CITY OF PORTLAND

BUILDING PERMIT

Job ID: 2011-11-2659-ALTR

has permission for installation of an Elevator and Interior Renovations (Single Family Residence), provided that the person or persons, firm or corporation accepting this permit shall comply with all of the provisions of the Statues of Maine and of the Ordinances of the City of Portland regulating the construction, maintenance and use of the buildings and structures, and of the application on file in the department.

Guide Rail Backing Construction Details:

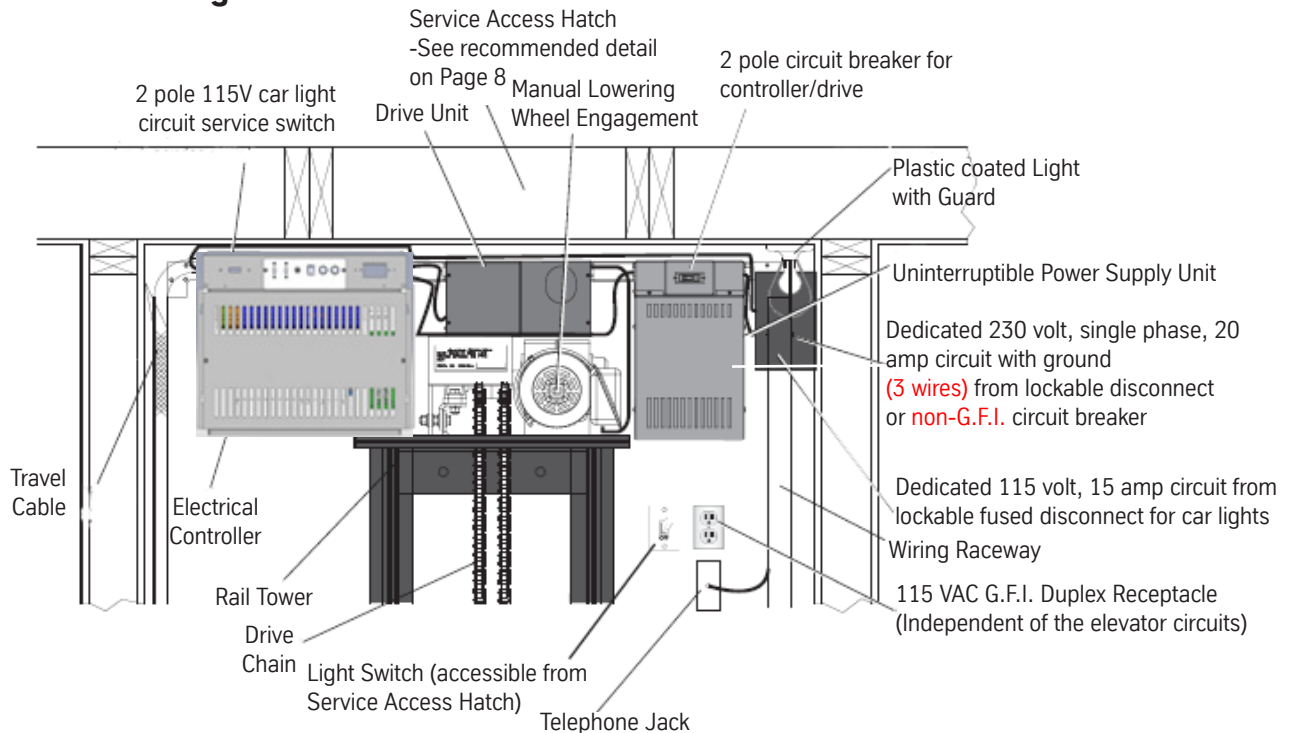
If all four walls of the Elevator shaft are being framed alike, a typical cross-section (from the second floor to foundation) of how the elevator shaft is framed (showing how the existing floor joist meet with the elevator shaft).

1. Cross section of all new Girders & how they are posted down to foundation.
2. Cross section/ framing detail for elevator shaft.
3. Finish Ceiling Height in the Bathroom
4. Section "A-1.1" indicated that the existing stairs was removed, if a new stairwell is created/

I drafted the section that illustrates what was already noted on the plan. Specifically, how the elevator shaft walls bear down to the basement slab or existing basement girder. The joists that are cut for the shaft bear on these walls. The only new girder bears on a post (also shown in the section) that bears to an existing interior foundation wall. I added a detail of the additional framing in the elevator wall where the rail is attached. This detail is per manufacturer's specification.
